**Our Case Number: ABP-313892-22**

**Re: Bus Connects Blanchardstown to City Centre Core Bus Corridor Scheme  
Blanchardstown to Dublin City Centre**

**Re: Bus Connects Blanchardstown to City Centre – ref ABP-313892-22**

Programme Title	BUSCONNECTS DUBLIN CORE BUS CORRIDORS INFRASTRUCTURE WORKS		
Drawing Title	BLANCHARDSTOWN TO CITY CENTRE CORE BUS CORRIDOR SCHEME GENERAL ARRANGEMENT		
Drawing File Name	Sheet Number	Status	Rev
BCIDC-ARP-GEO_GA-0005_XX_00-DR-CR-0022	22 of 40	A	M01

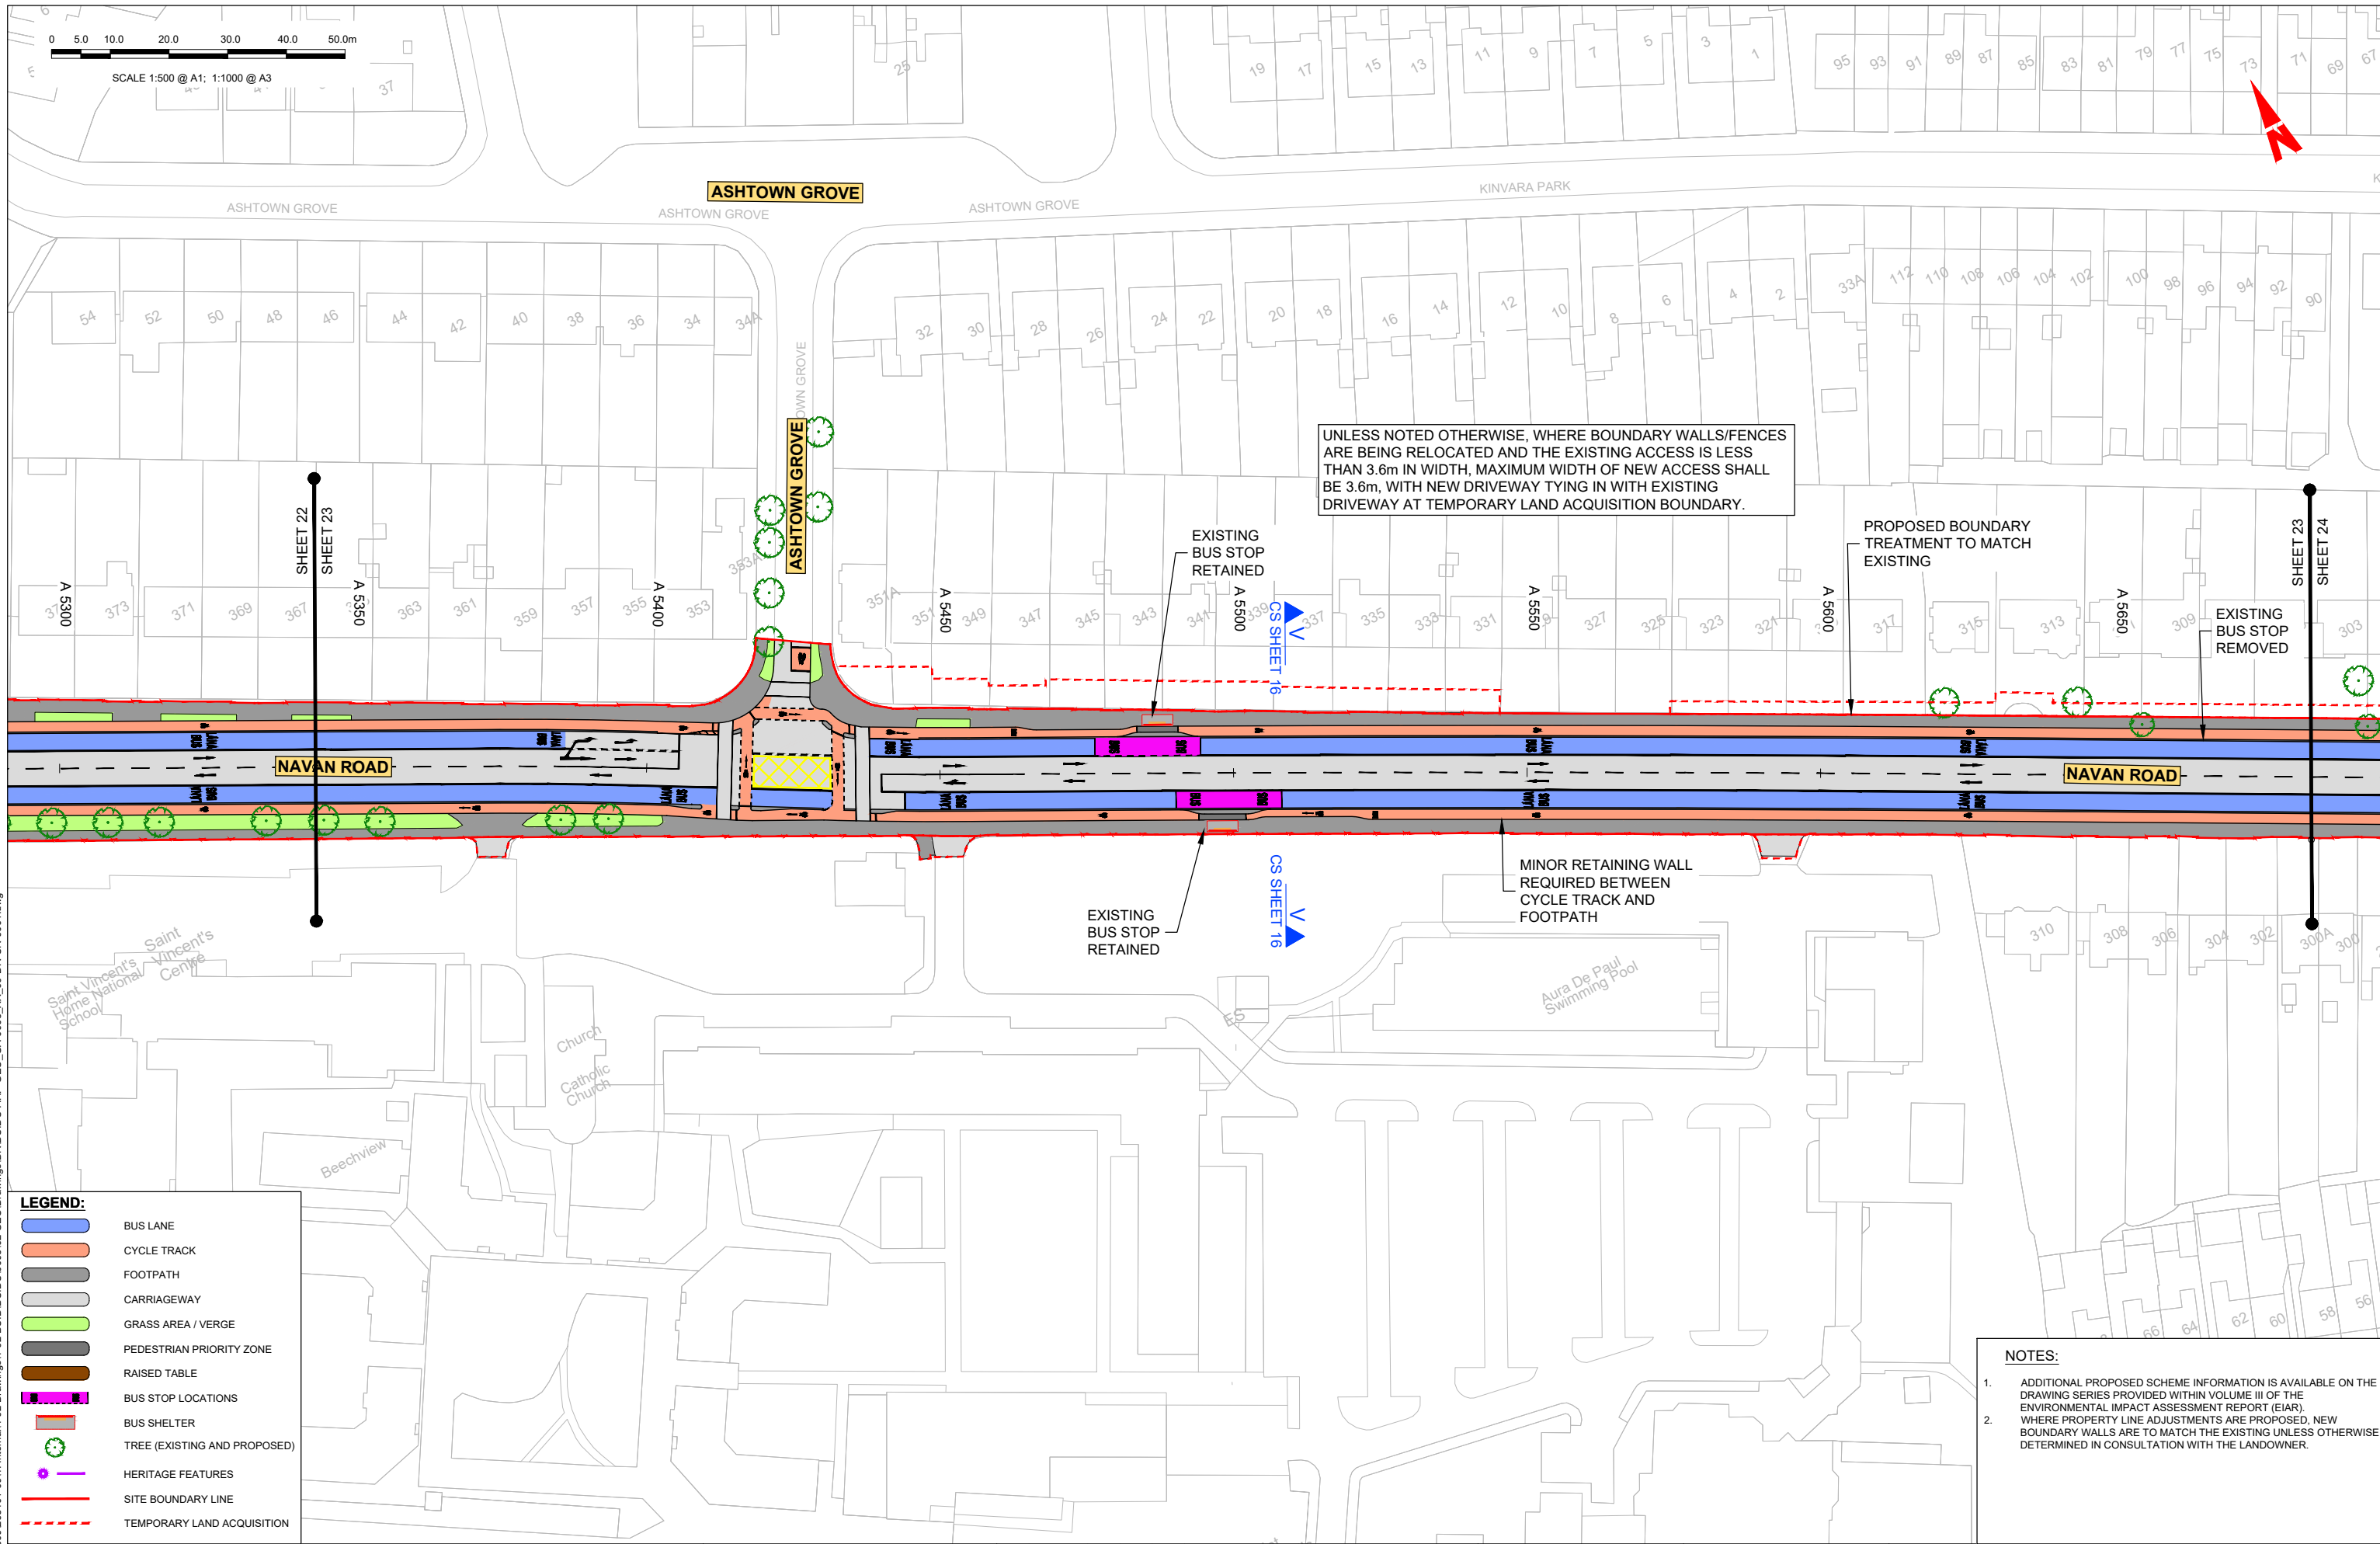
Again, I welcome that overall there will be an increase in trees along the BusConnects route. However, the NTA choice of the stretch of road for which statistics were provided in its response to highlight tree planting from Parkway station downplays the extent of tree removal along footpaths on the Navan Road between the Halfway House and Old Cabra Road. About 60% of the 230 trees mentioned in the NTAs response are proposed to be planted between Navan Road Parkway and the current Ashtown Roundabout (sheets 18-21<sup>8</sup>) or are not directly along the footpath where existing trees will be removed. Within the current proposals, the 2.5km segment of the Navan Road between the Halfway House and Old Cabra Road will have a significant amount of tree removal, with limited replacement trees (sheets 22 to 27).

This part of the BusConnects route is expected to have 38.5% of tree removal for the whole scheme but only 11% of replacement tree planting<sup>9</sup>. The issue is particularly severe for the south side of the Navan Road where I estimate 84 trees are planned to be removed but only 20 replaced (a 76% reduction), with replanting concentrated outside the Belvedere sports grounds and outside the Eir premises near Hampton Green. *See annex 2 for a summary of the relevant maps.*

Sheet	Navan Rd segment	Net gain/(loss)	Estimated distance	Comment
21	Portion – Ashtown roundabout to no. 385 Navan Rd	7	90m	
22	No. 383 Navan Rd, near Kempton entrance to 367 Navan Rd, before Ashtown Grove entrance	-23	350m	
23	365 Navan Road, before Ashtown Grove entrance to 305 Navan Rd	-28	330m	
24	303 Navan Rd to 243 Navan Rd, after Kinvara Ave/Baggot Rd junction	-6	350m	Most planting on North side of Rd
25	241 Navan Rd to 175 Navan Rd, after petrol station	-7	330m	Planting on South side of road
26	173 Navan Rd to Garda Station after Nephin Rd junction	-6	350m	All planting on North side of road
27	Garda station to Hampton Green entrance	-11	390m	Planting mainly on North side except near Hampton Green
28	Hampton Green entrance to Old Cabra Rd junction	2	350m	All planting on North or centre of road with 8 trees removed from South side
	<b>Total</b>	<b>-72</b>

1. To achieve significantly reduced tree removal or significantly increased replanting along the Navan Road from the entrance to Kempton to Skreen Road so that the number and placement of trees is consistent with Design Manual for
2. Urban Roads and Streets (DMURS) guidance of at least every 14-20 meters apart<sup>2</sup>.
3. Where replanting is the chosen option that a diversity of trees are planted, while disease susceptible trees such as Sorbus Aria are avoided.
